CITY OF ALBUQUERQUE

July 10, 2018

**Re: Del Webb @ Mirehaven Units 3 & 4
Grading and Drainage Plan
Engineer's Stamp dated: 7/9/2018 (H09D017G)**

EXHIBIT D
POND DETAIL

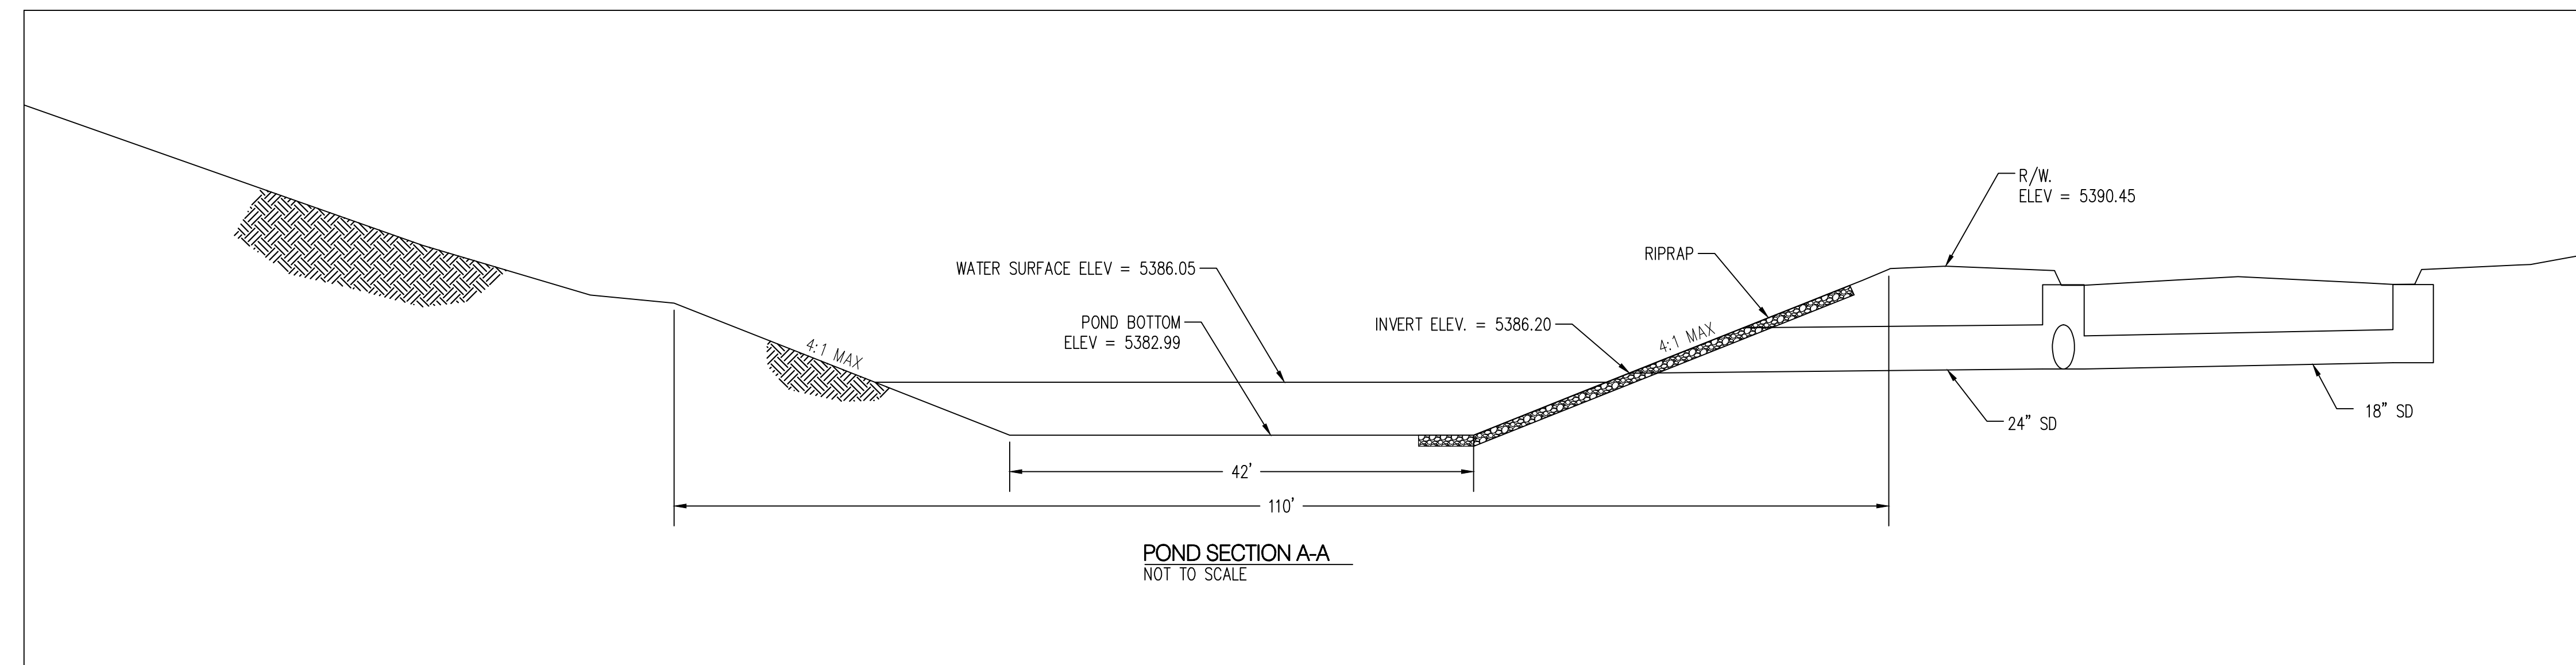
3. HGL calculations per DPM and profiles showing HGL,
4. A Detail of the pond outlet structure. Hydraulic calculations must be contained in a bound report with an engineer's stamp and signature on it.
